PUBLIC WORKS DEPARTMENT  
501 Delta Avenue □ Marysville, WA 98270  
(360) 363-8100

Re: Gamlam Subdivision – *Concurrency Recommendation*  
PA23004

SHEET DESCRIPTION: **PRELIMINARY PLAT**

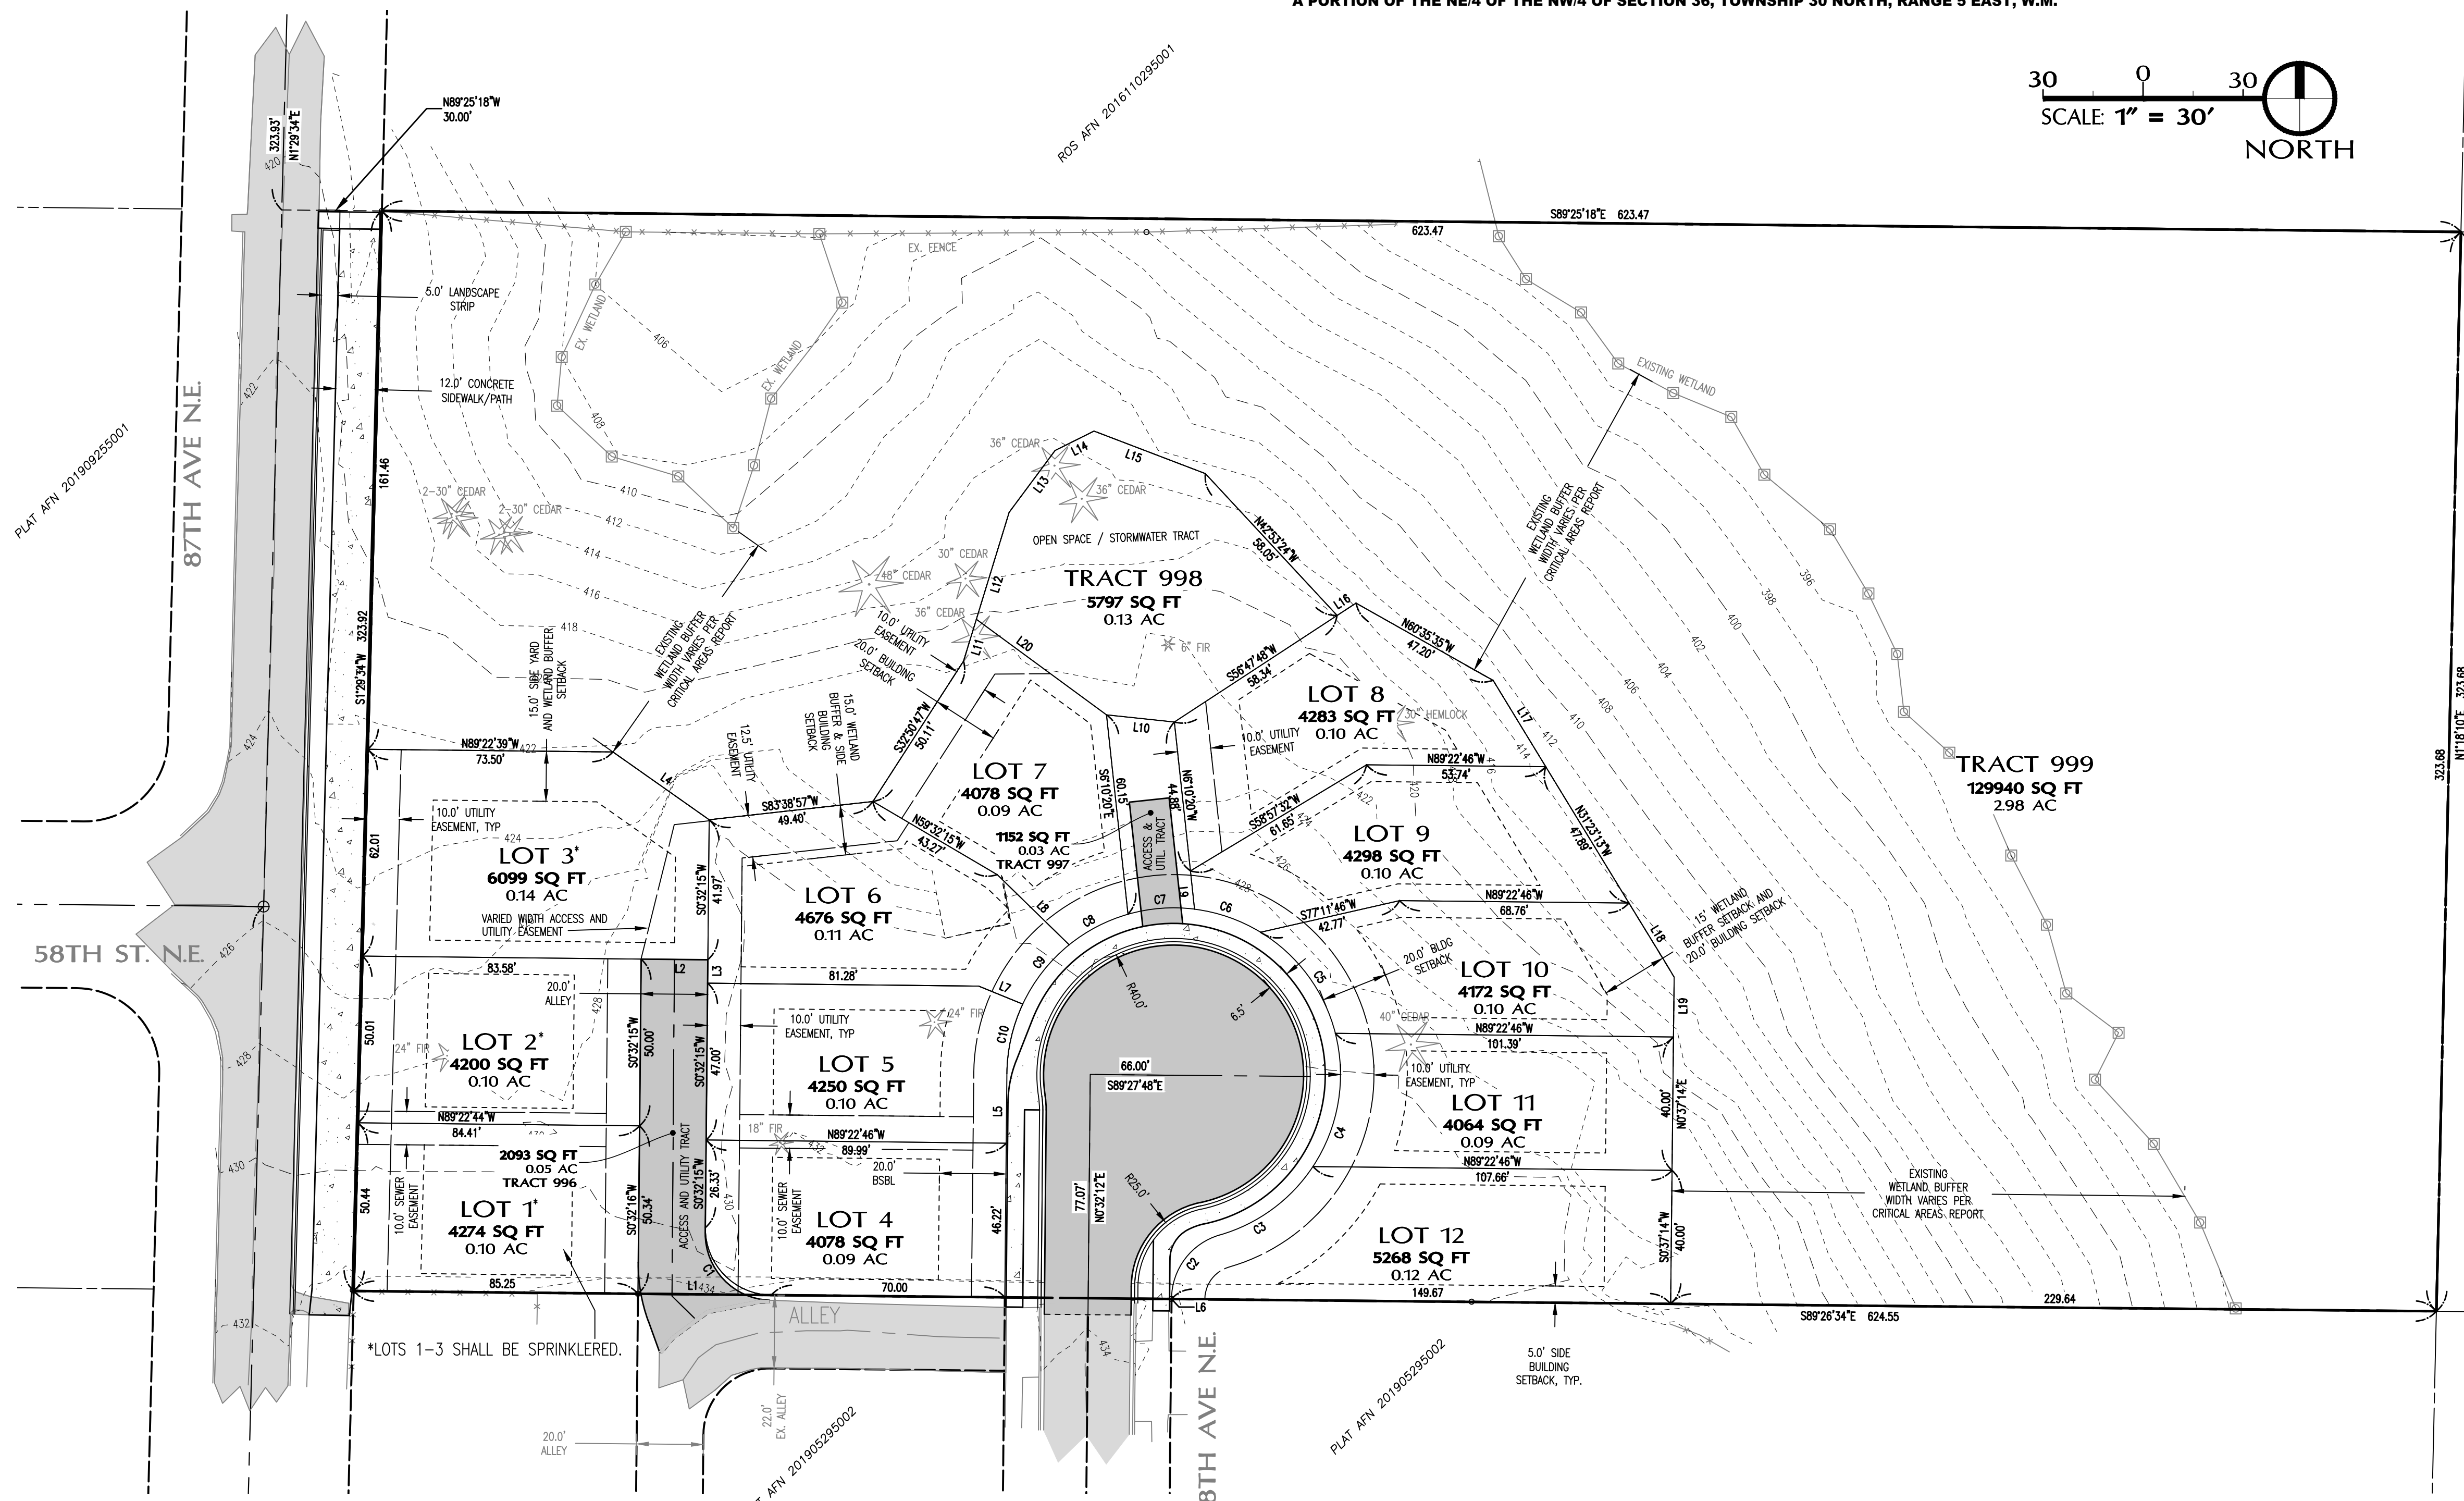
2. The applicant shall be required to dedicate public right-of-way in order to accommodate the proposed internal plat roads, in accordance with MMC 12.02A.110(1)(c), *Dedication of Road right-of-way – Required setbacks*. Right-of-way widths and required dedication shall be determined by the City Engineer.

3. The applicant shall be required to construct frontage improvements along internal plat roads and 87<sup>th</sup> Avenue NE, prior to final plat approval. Roadway improvements, channelization, site access and lighting plans will be required to be reviewed and approved by the City Engineer, prior to construction plan approval.

4. Applicant shall improve the intersection of Tract 996 and the existing alley to the south to a full hammerhead turn-around configuration and sprinklers shall be installed in lots 1, 2, and 3.
